**[FWD: first response from Portland building inspection]**

Subject: 89 Pleasant Ave., PI, BP#2017-01190 plan review comments
From: Jeanie Bourke <jmb@portlandmaine.gov >
Date: Tue, September 26, 2017 4:01 pm
To: "rory@thesellersplace.com" <rory@thesellersplace.com>, Keri Ouellette <k ouellette@portlandmaine.gov>

I am in review of this permit for building code compliance and have some comments for you to address in order to continue with this review. Please provide information for the following items:

S1

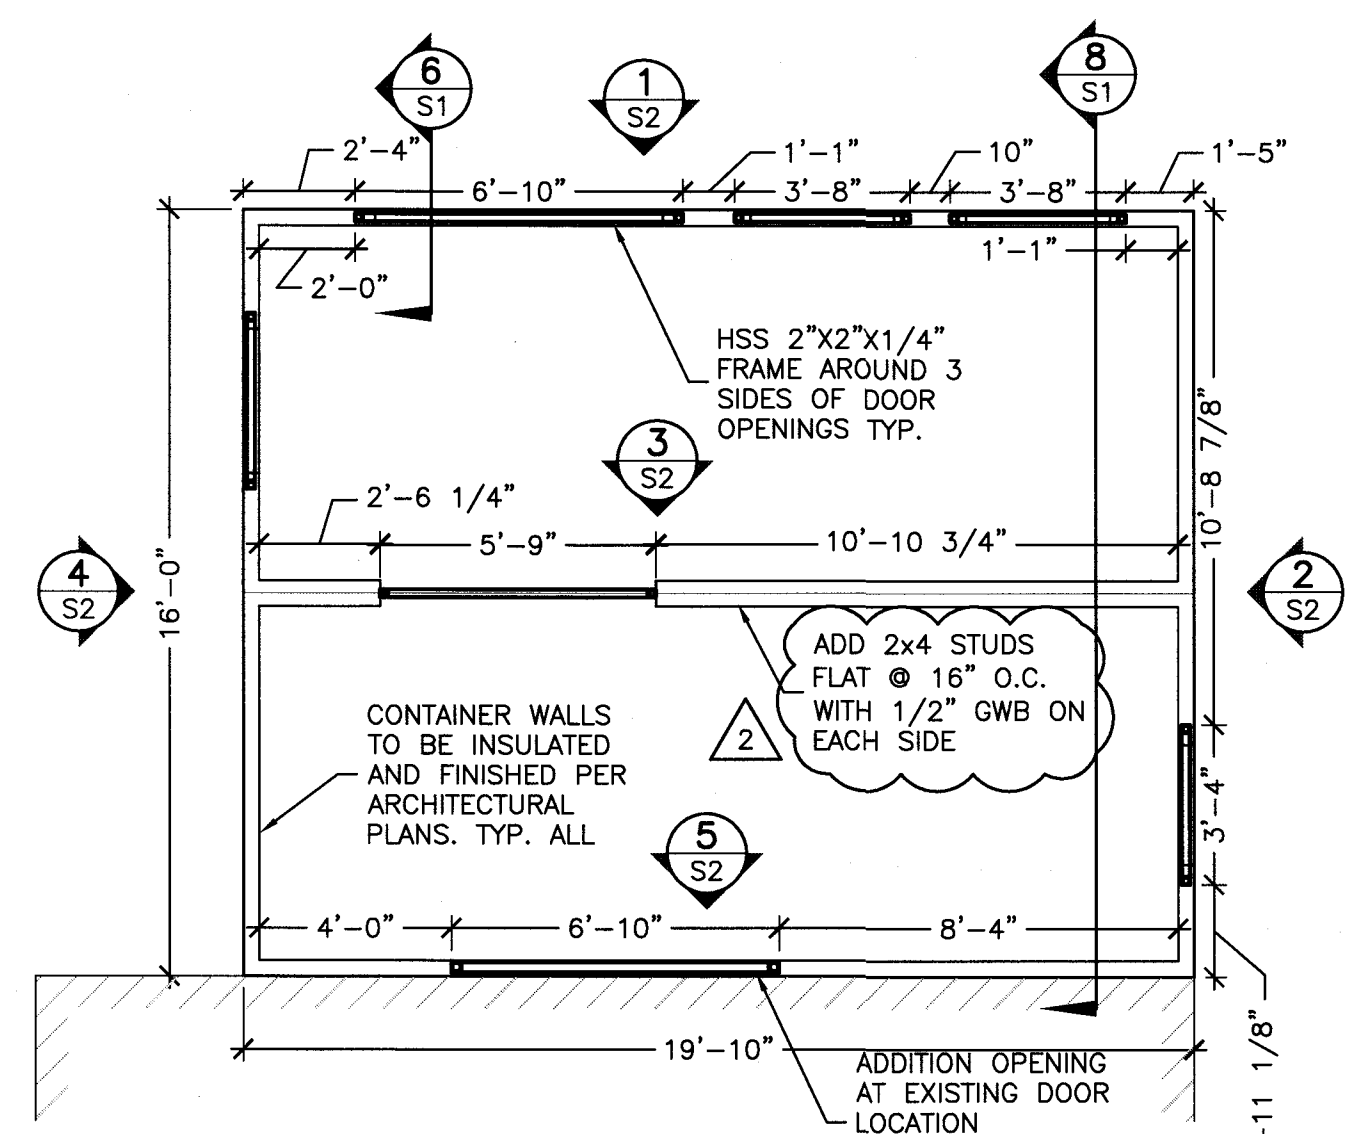
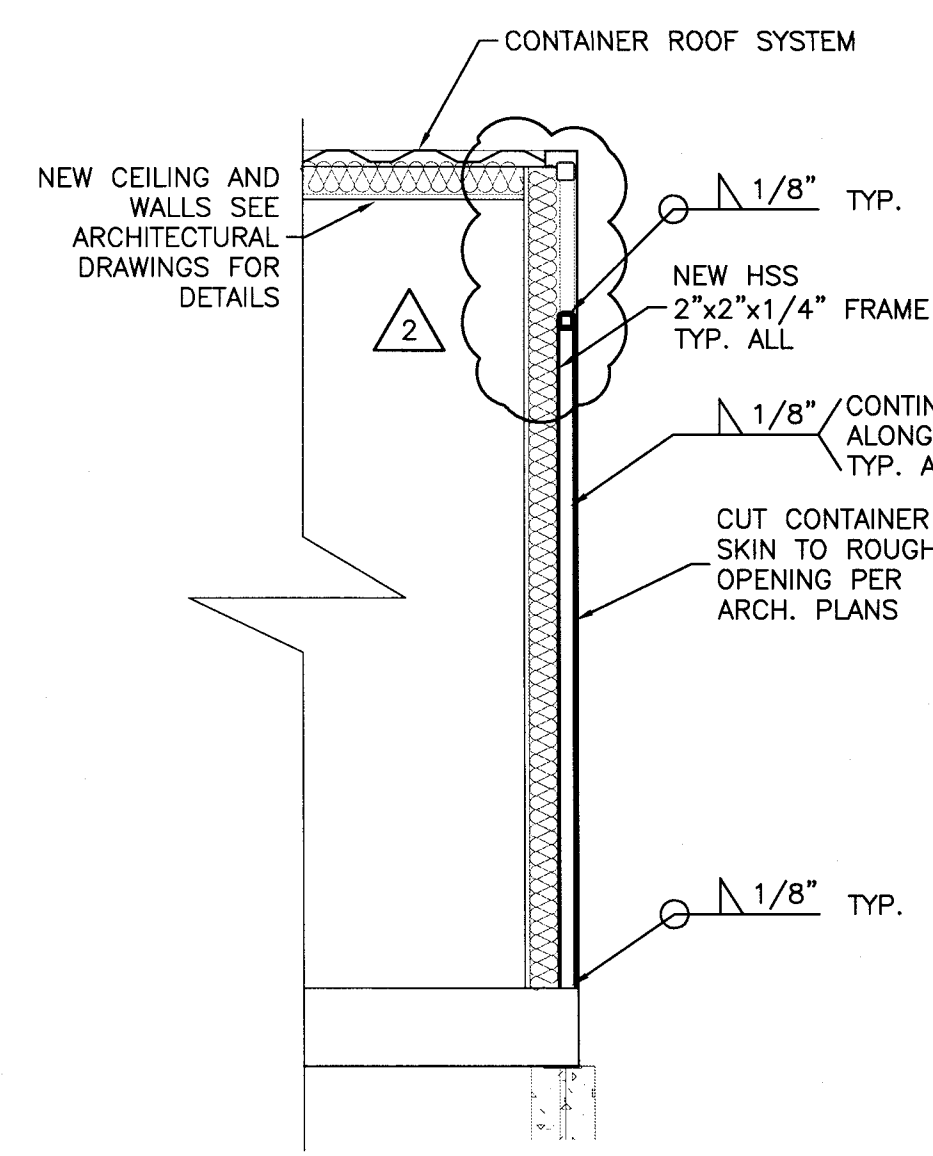
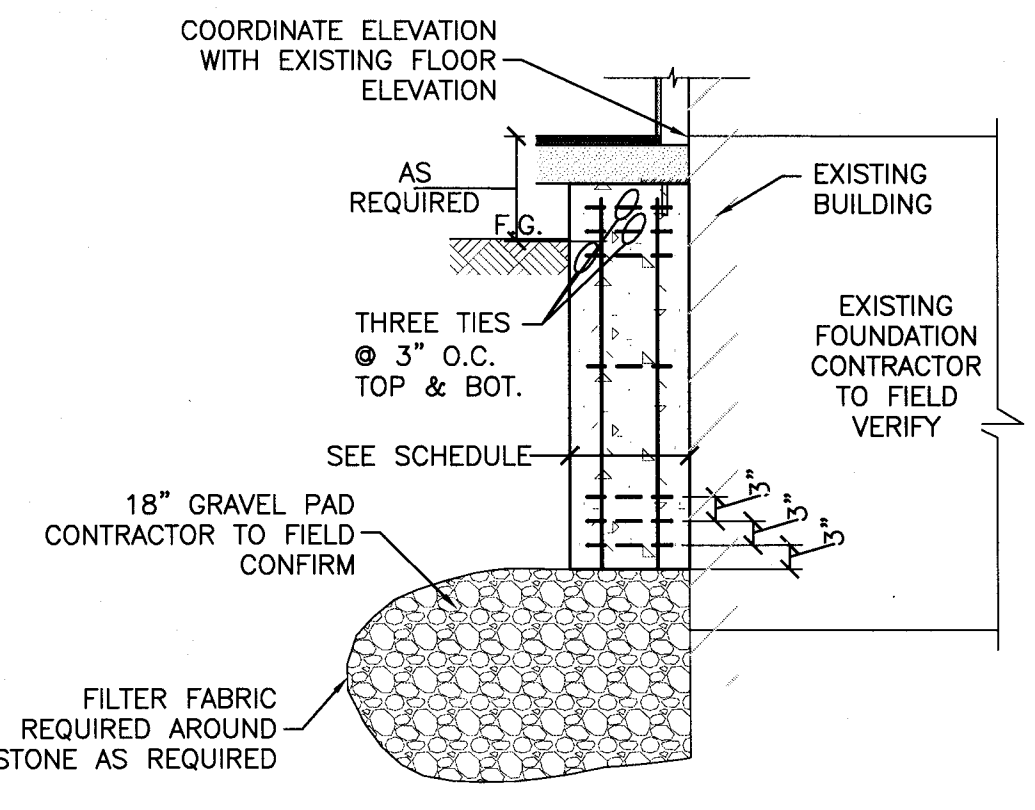
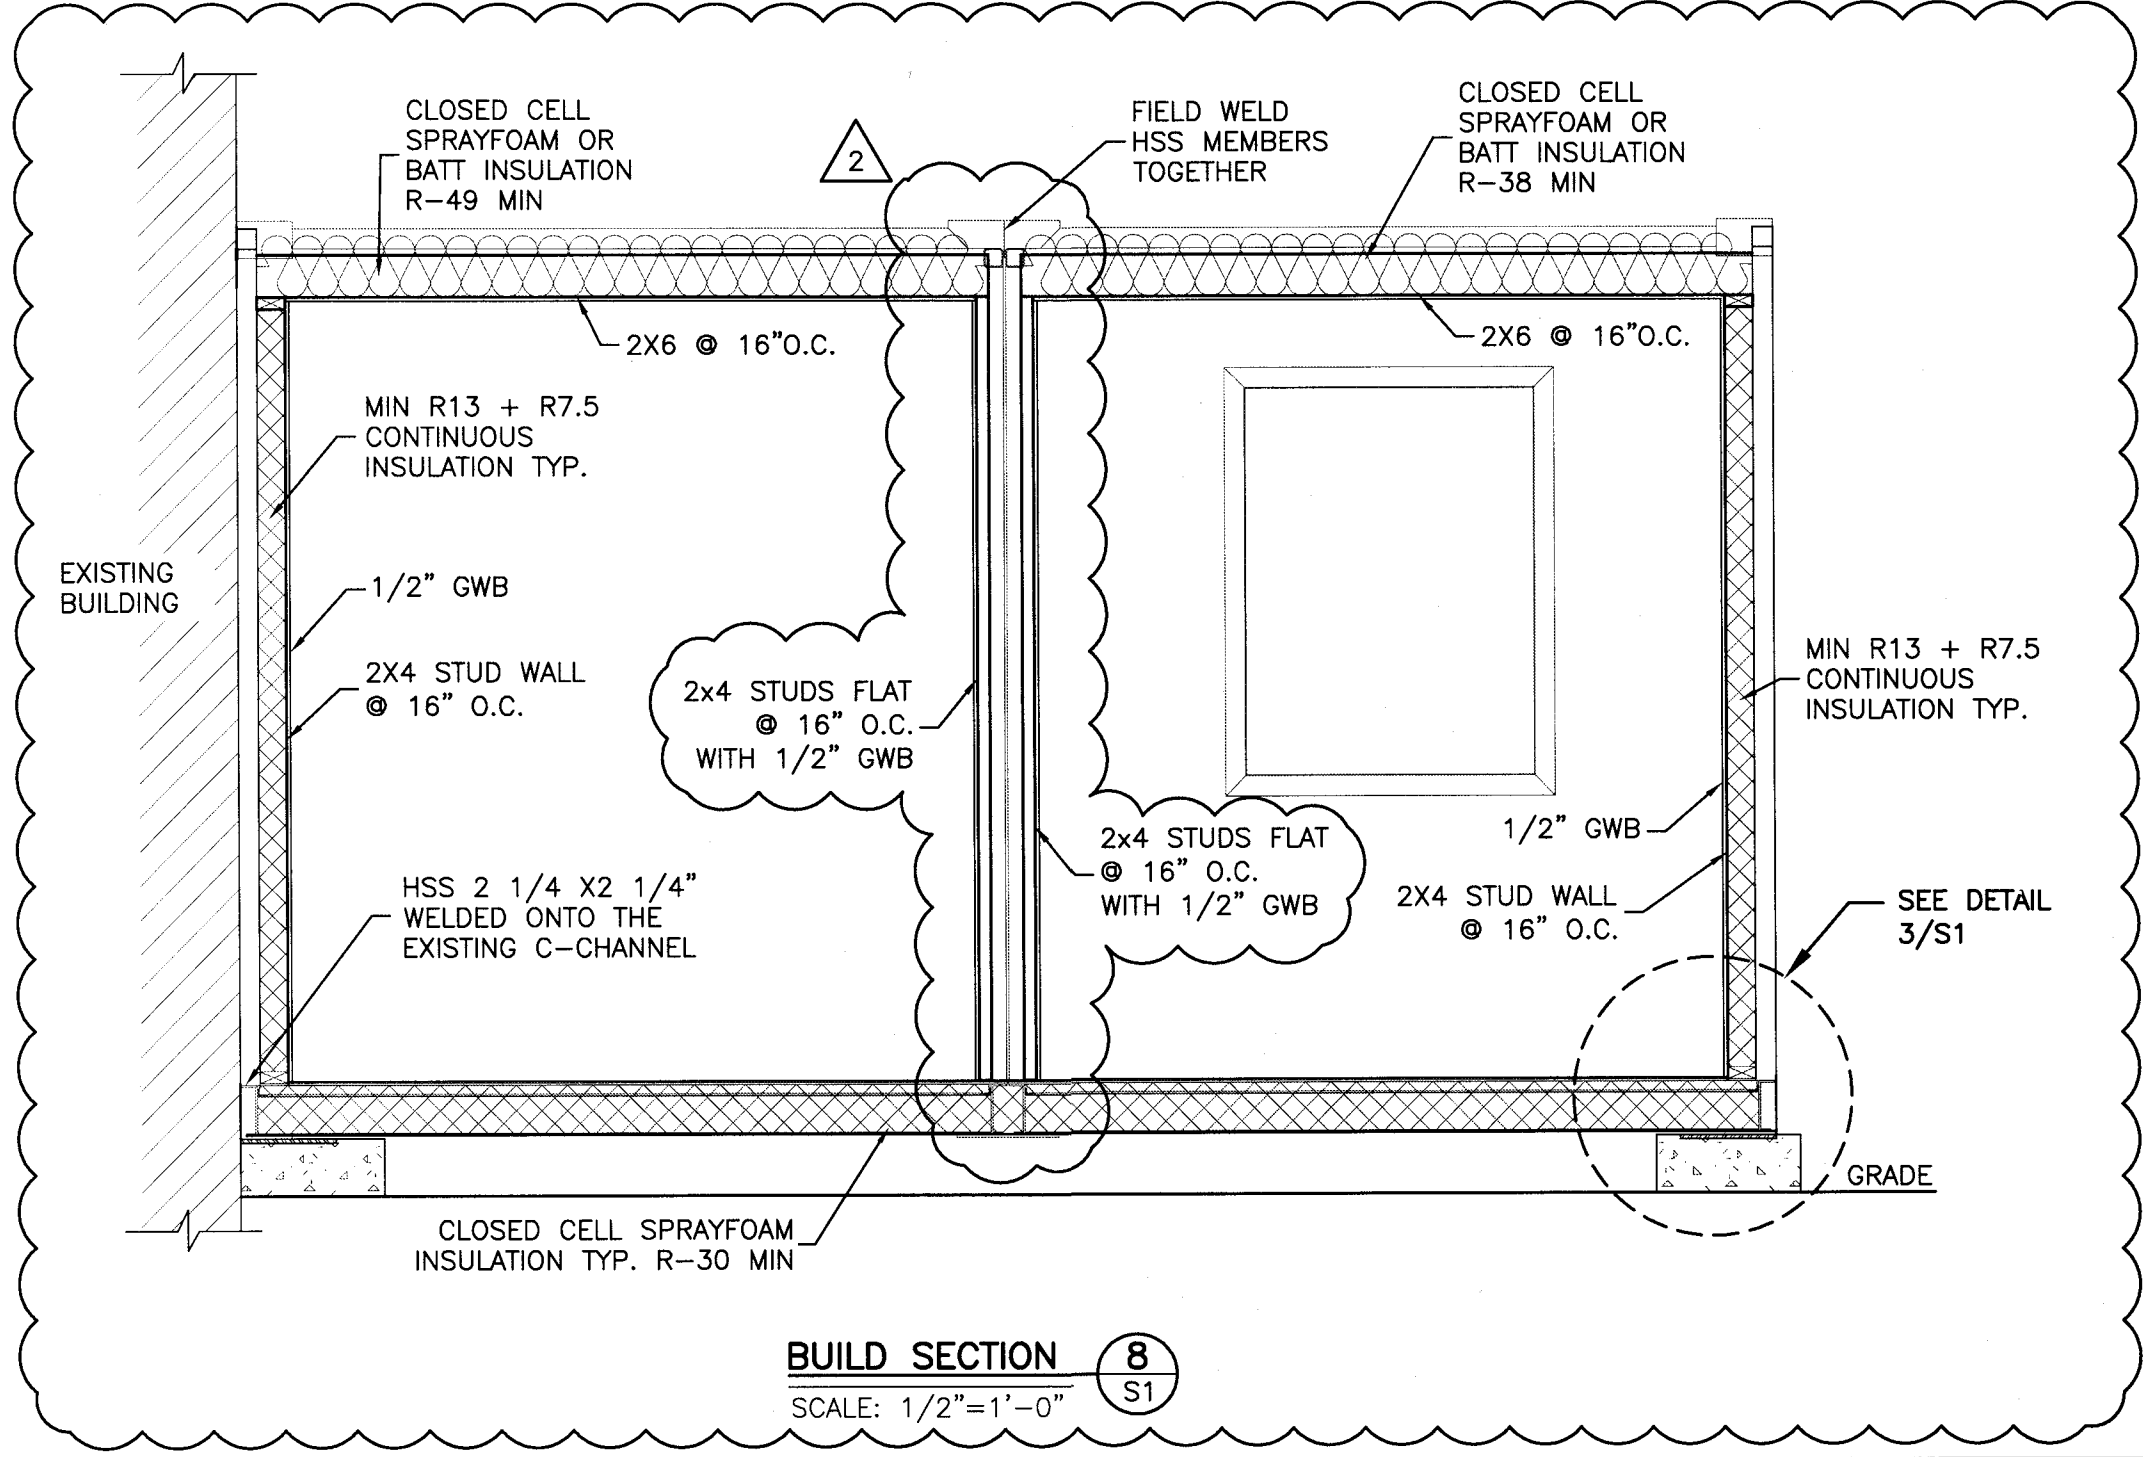
3. Storage shipping containers that are modified to be occupied as habitable structures are not recognized in the code. These are not constructed per conventional standards and practices, therefore, all modifications shall be reviewed and designed by a structural engineer per the prescribed loads, including parameters for the condition of the container.

4. Attachment and anchoring details of the addition to the foundation are required, as well as these details for the rooftop deck materials and guardrails. The height of the guardrail is not compliant at less than 36" and opening dimensions are required.

Yes. The city is already aware of the engineering firm (Plymouth Engineering - Keith Ewing) that we use and Jeannie and Mike have already met him in their office. We will put you in touch with him directly so that you may work through the details. Rory will remember him from our meeting that day.
